Submission: SSD-77211717 – Lot 303 Croatia Avenue, Edmondson Park South

Thank you for the opportunity to provide feedback on the State Significant Development (SSD) proposal for the construction of an affordable housing development at Edmondson Park South, comprising approximately 58 dwellings.

Drawing Name
Elevations

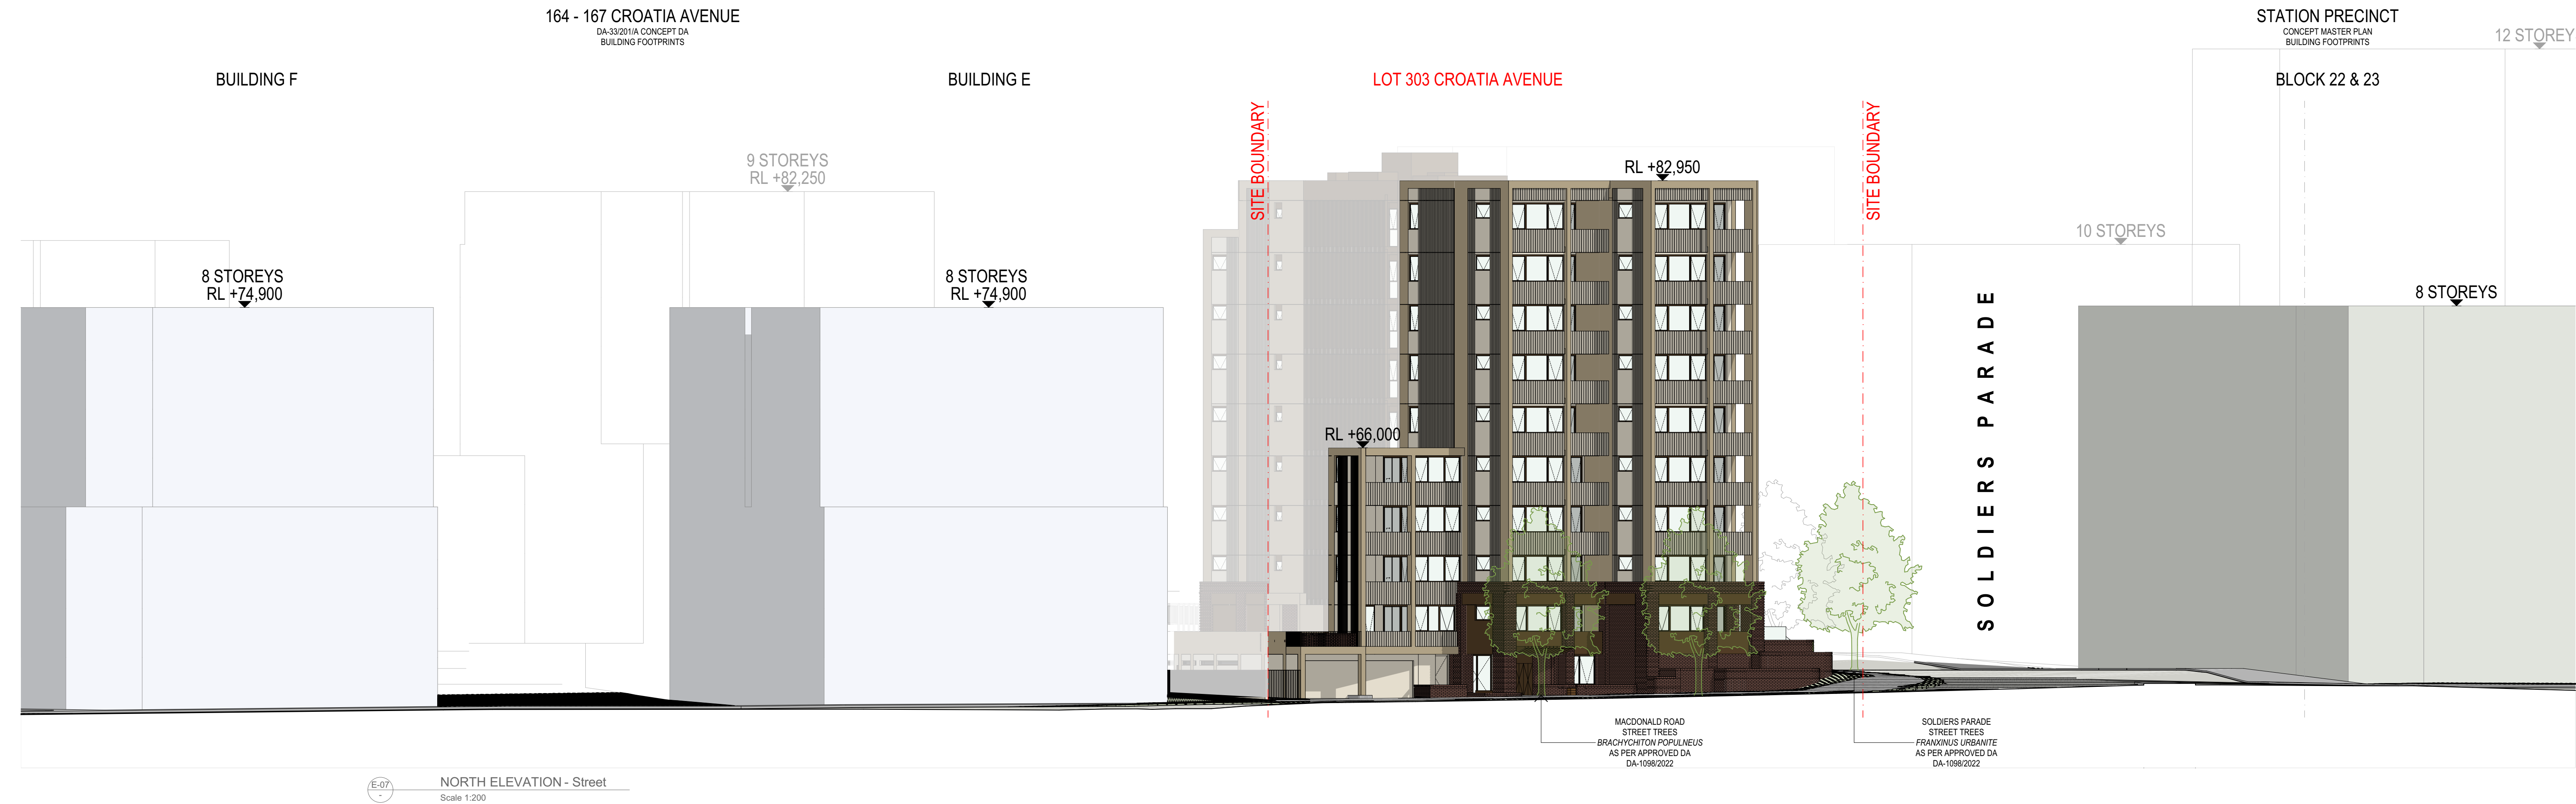
The architectural concept is generally strong, particularly the podium and use of durable materials. However, the building's length along Soldiers Parade risks creating a visually monotonous façade. More variation in materiality, balcony treatment, or recesses could break up the mass and better align with the principles of 'Better Placed'

and SEPP 65. The building should continue to prioritise human scale and visual interest at street level.
